MEMORANDUM

DATE: February 15, 2024

SUBJECT: PUDSP-21-010 – Grandview Reserve (with PSSG)  
Eighth Submittal (“V11”)

SHEET NO.
GR4 07

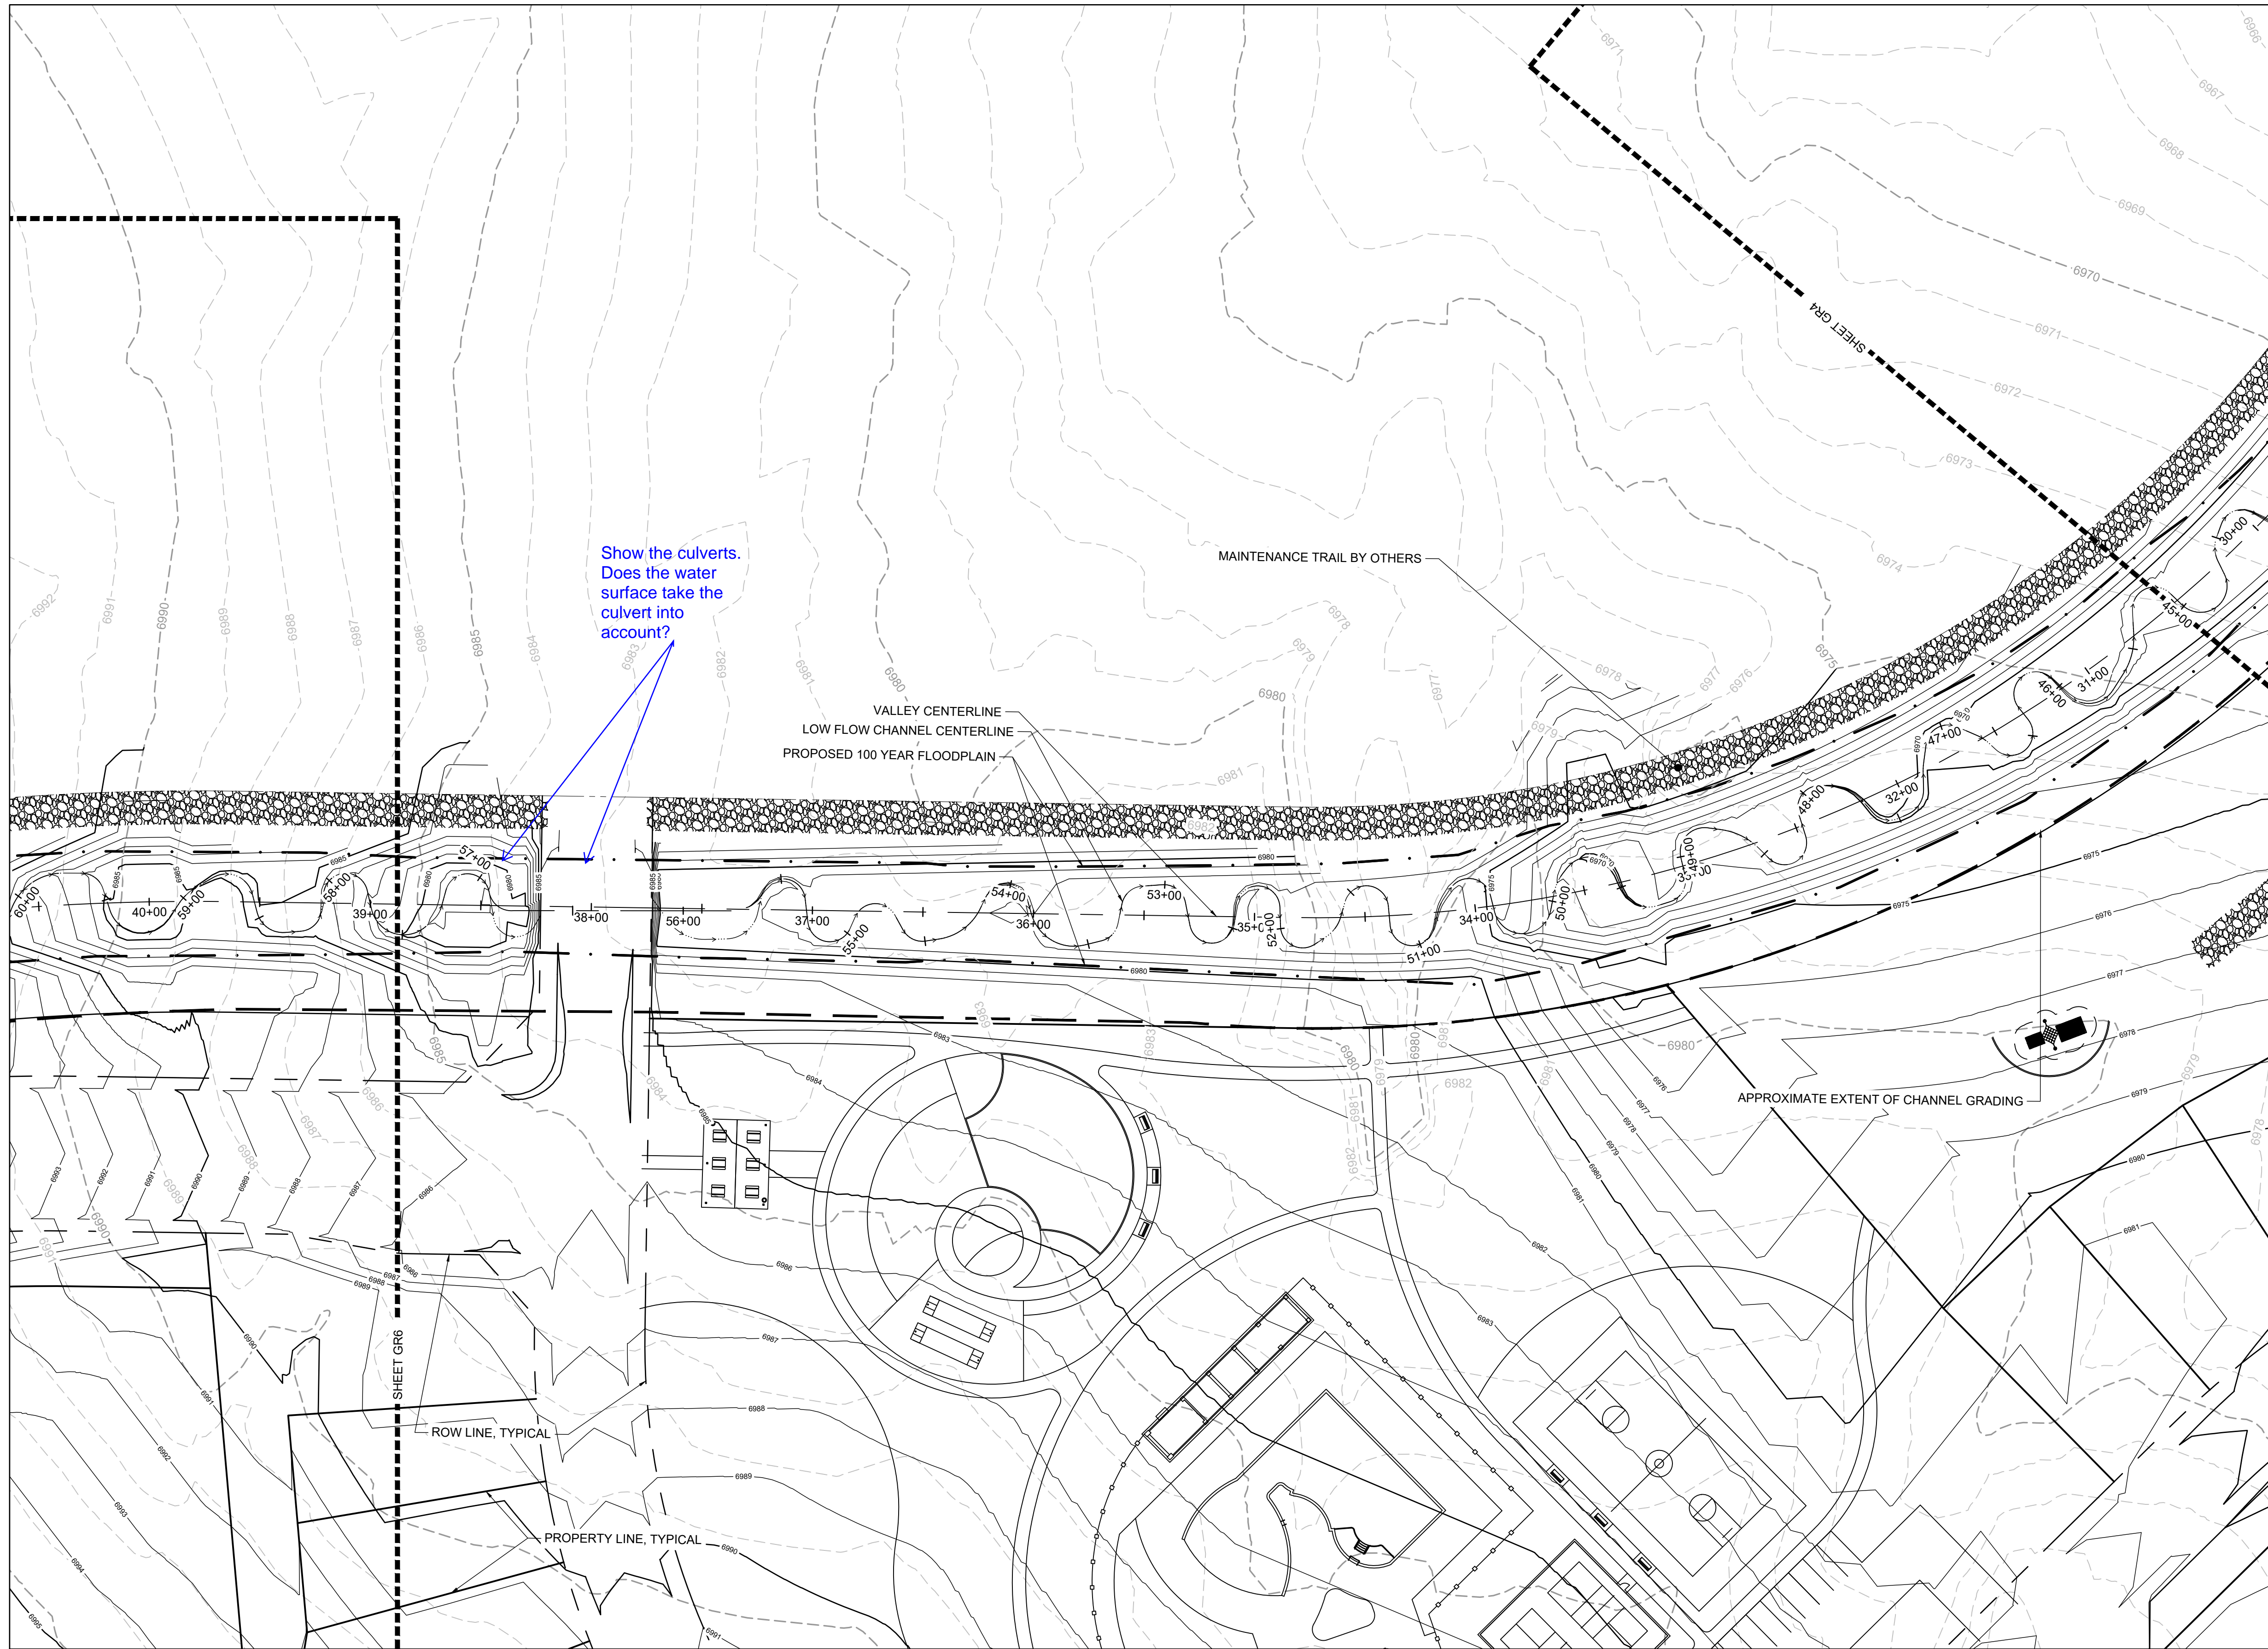
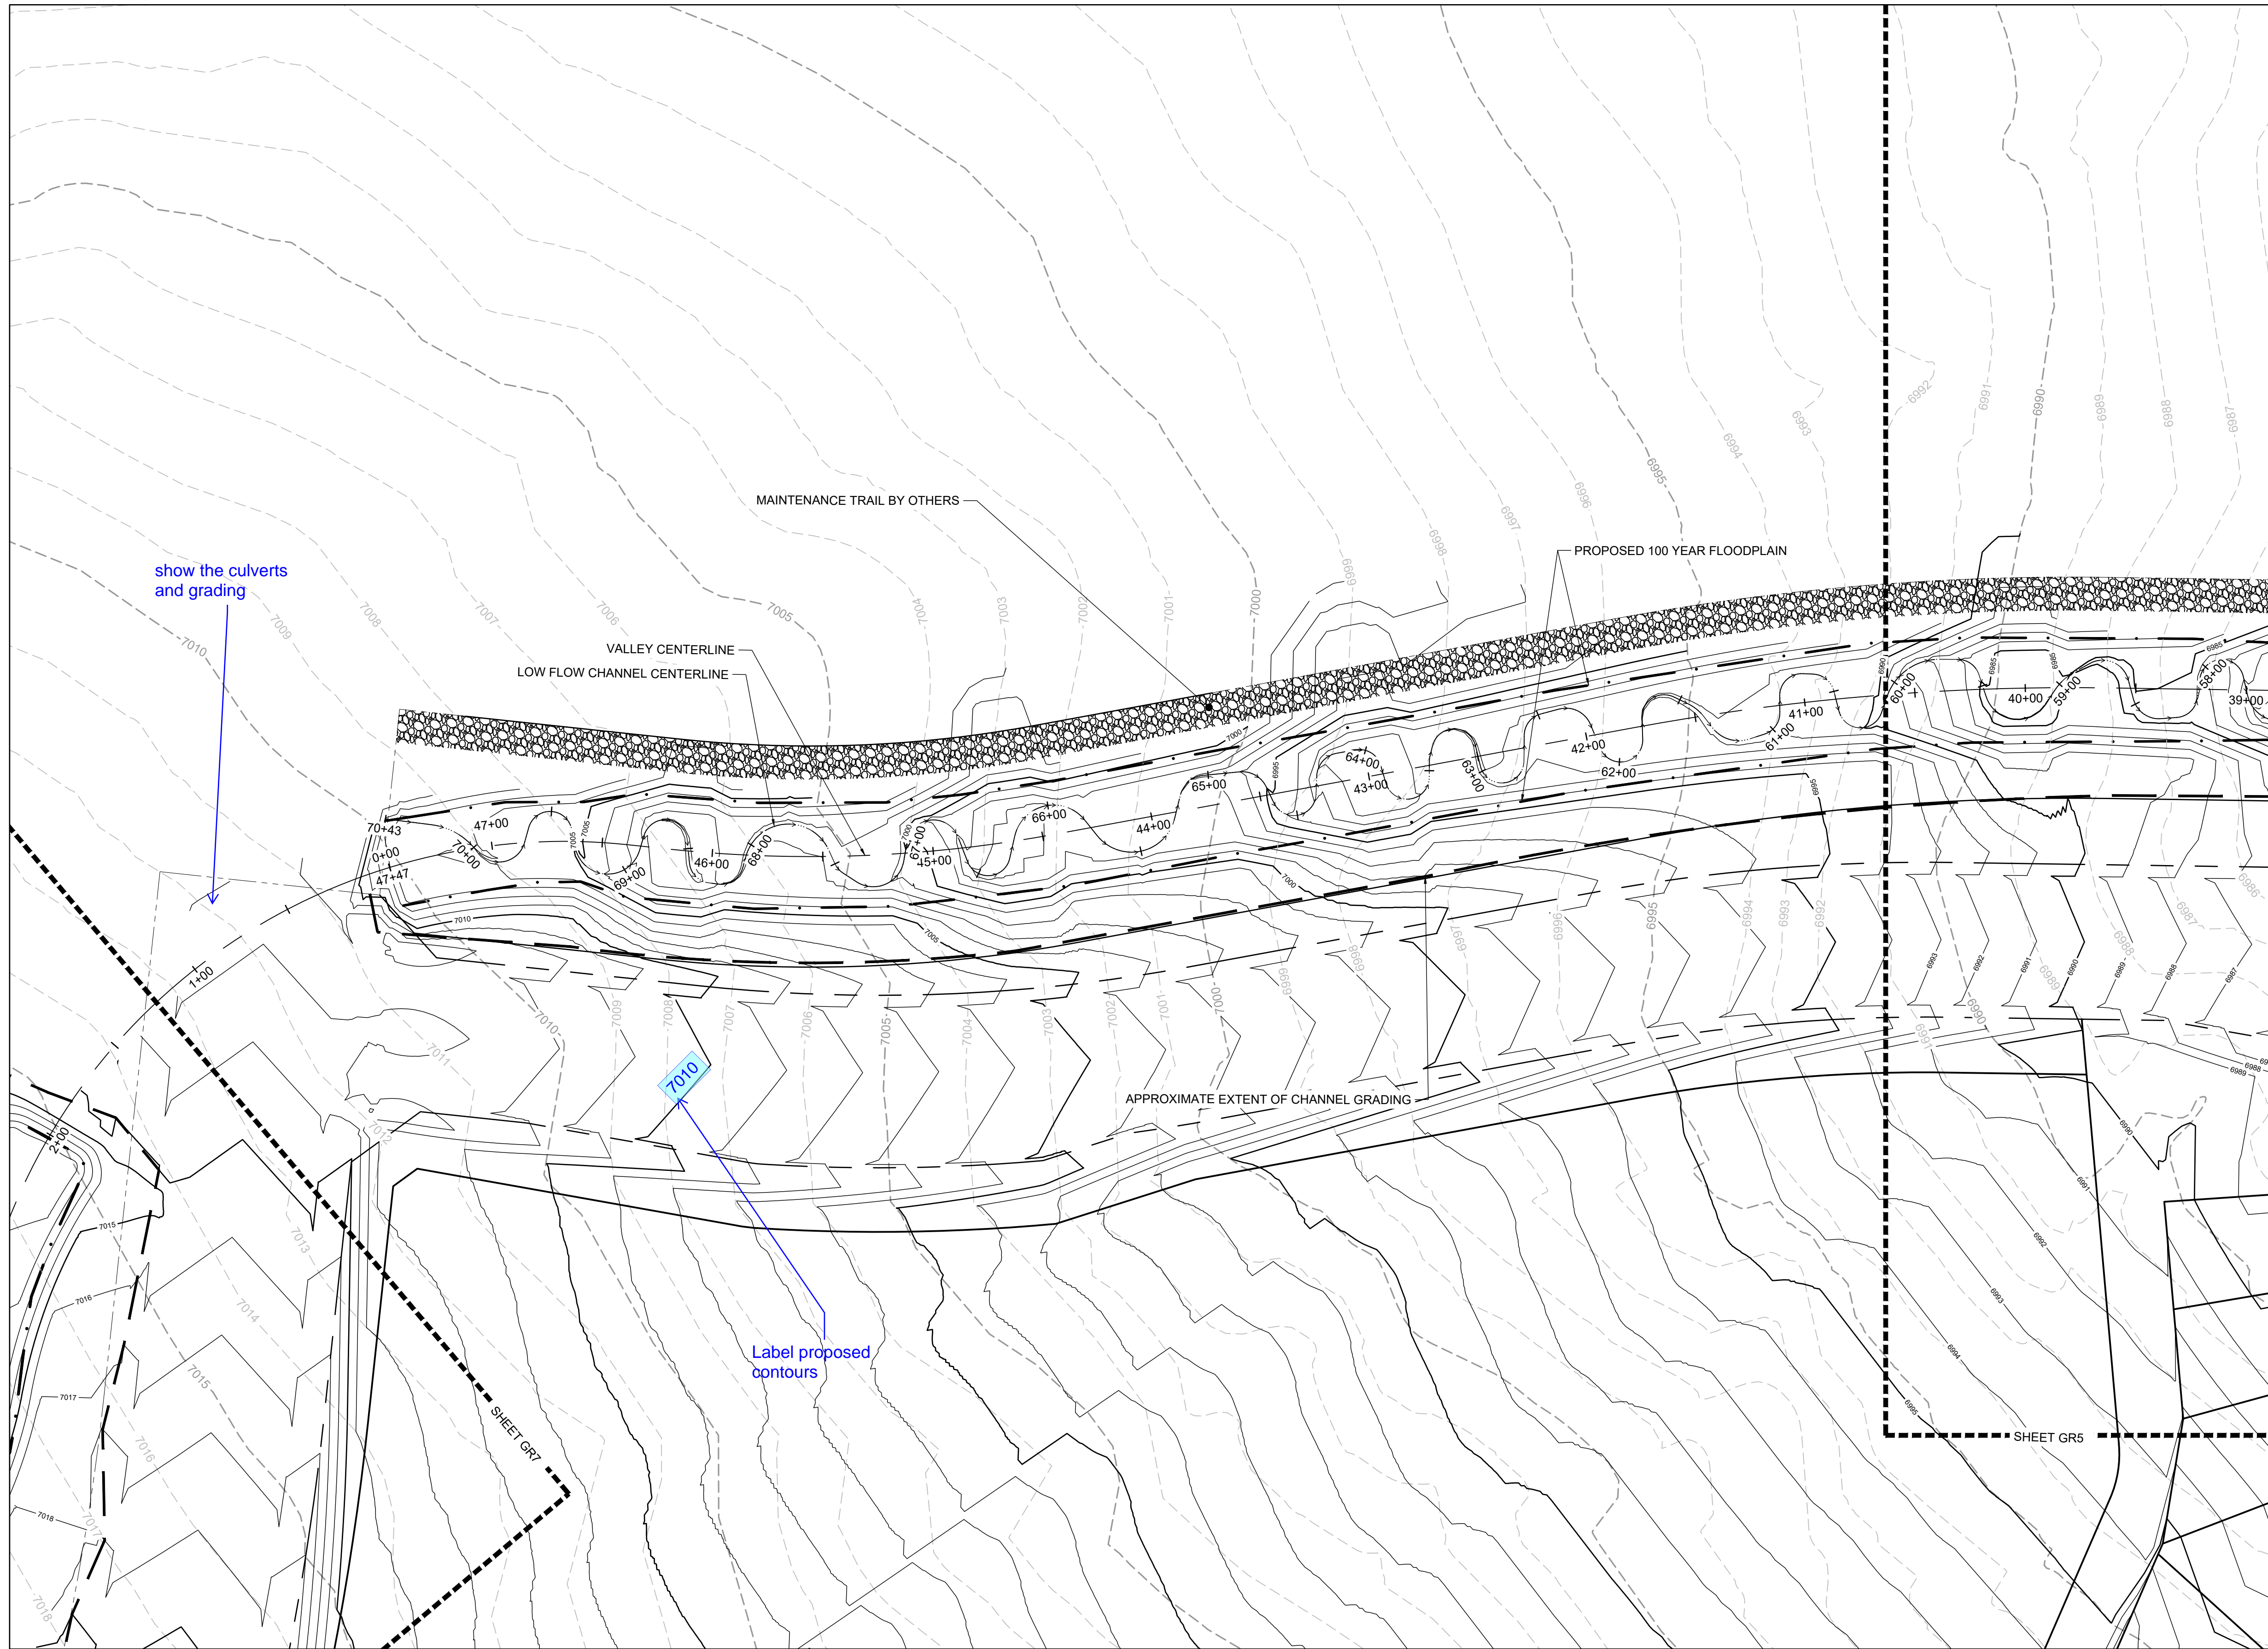
- a. Regarding the "Summary and BOD" document, see email dated 10/8 with cursory comments:
    - i. The cross-section template appears to have been run through the whole channel alignment, creating berms along the channel in some locations. I just want to verify that those will be graded out or widened where appropriate. (see attached redlines highlighting some of the areas of concern). Partially resolved; the grading needs to be completed. **(To be reviewed under CDR-22-008)**

- a. Resolved.
  - b. Berms/levees along the channel next to development areas need to be removed and if fill is added to contain the floodplain it needs to be graded out to an even surface from the edge of the channel (reference CWCB and USACE regulations). **Partially resolved; the very southeast end of the channel is still of concern, with the proposed future Waterbury lots to the south. (To be reviewed under CDR-22-008)**
